# Adams School Redevelopment

## **Addendum No. 2** to Contract Documents

March 23, 2012

CONTAMINATED SOIL COVERING SECTION N.T.S.

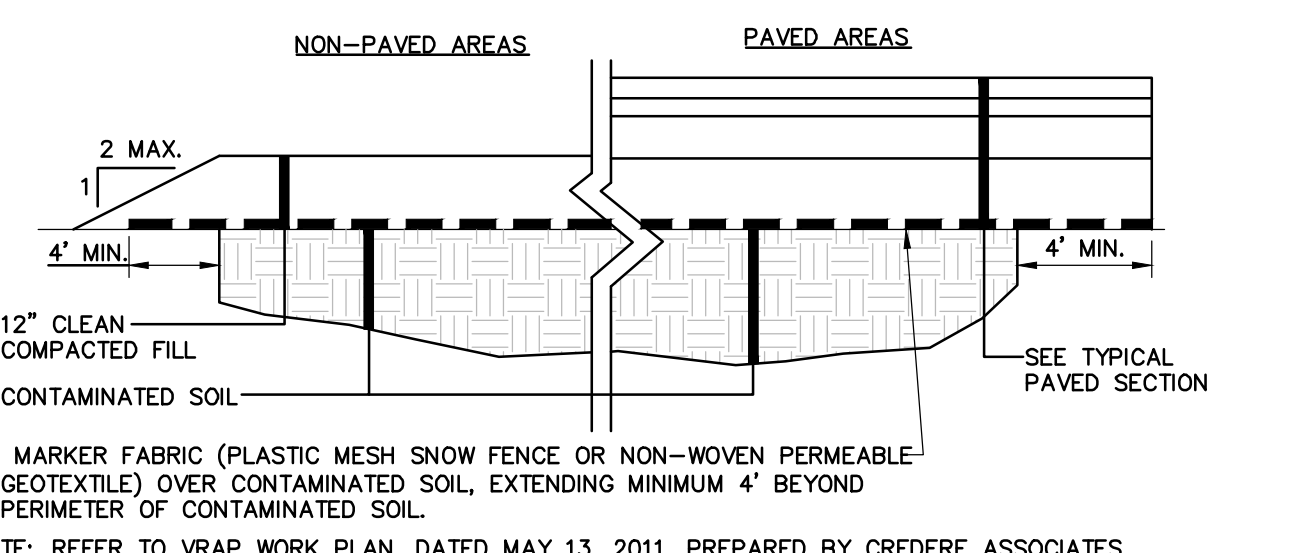
3.04.A.3: ADD:

All clean fill materials used during the construction of the soil cover shall be free of contamination as indicated by an appropriate Certificate of Analysis.

**S1.1**

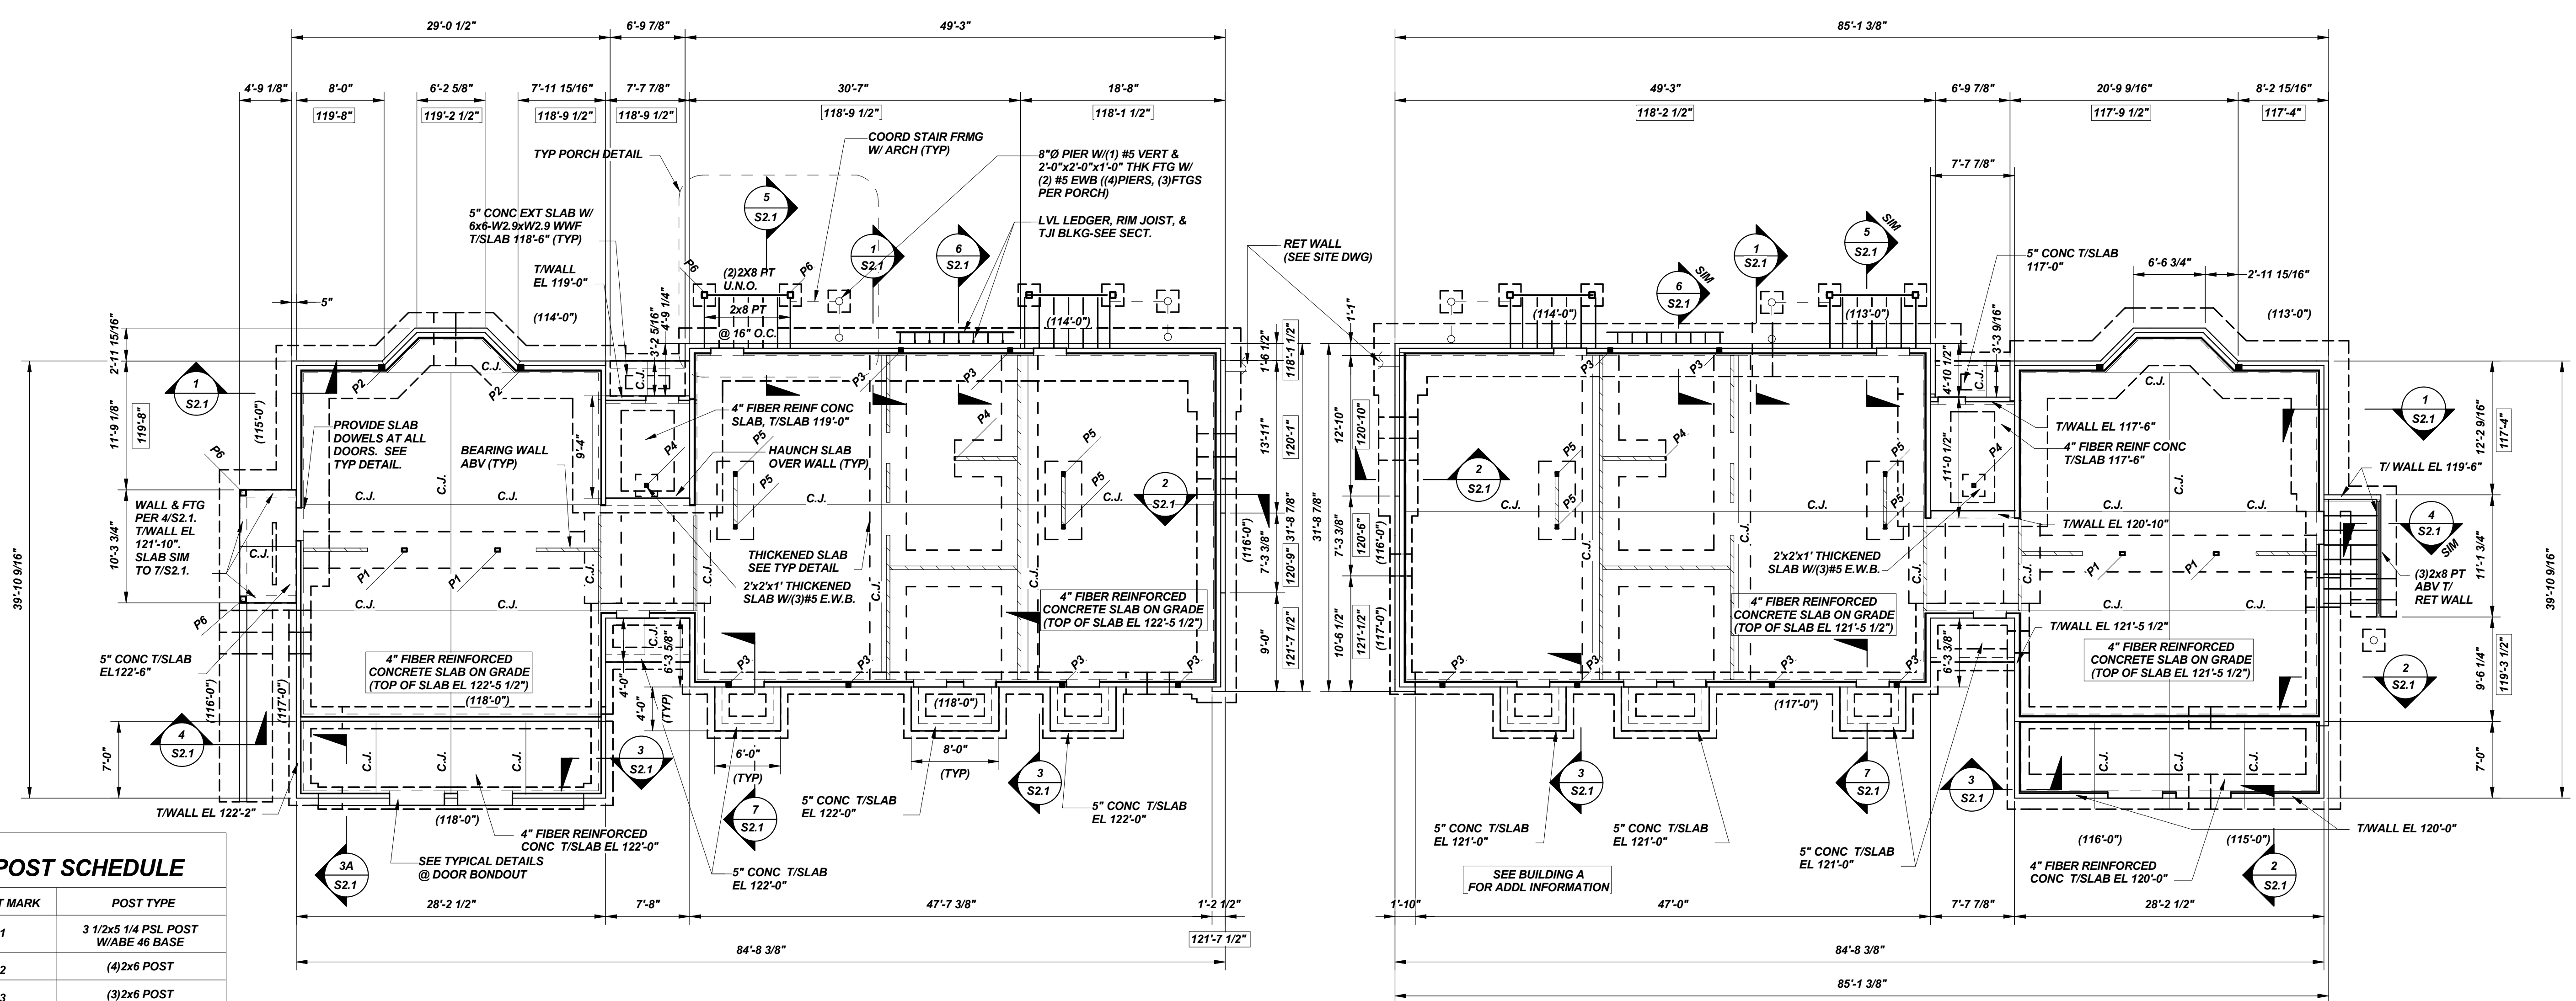
- Sheet S1.1: MODIFY as shown on attached S1.1/Addendum 2.  
Sheet S1.2: MODIFY as shown on attached S1.2/Addendum 2.  
Sheet S1.3: MODIFY as shown on attached S1.3/Addendum 2.
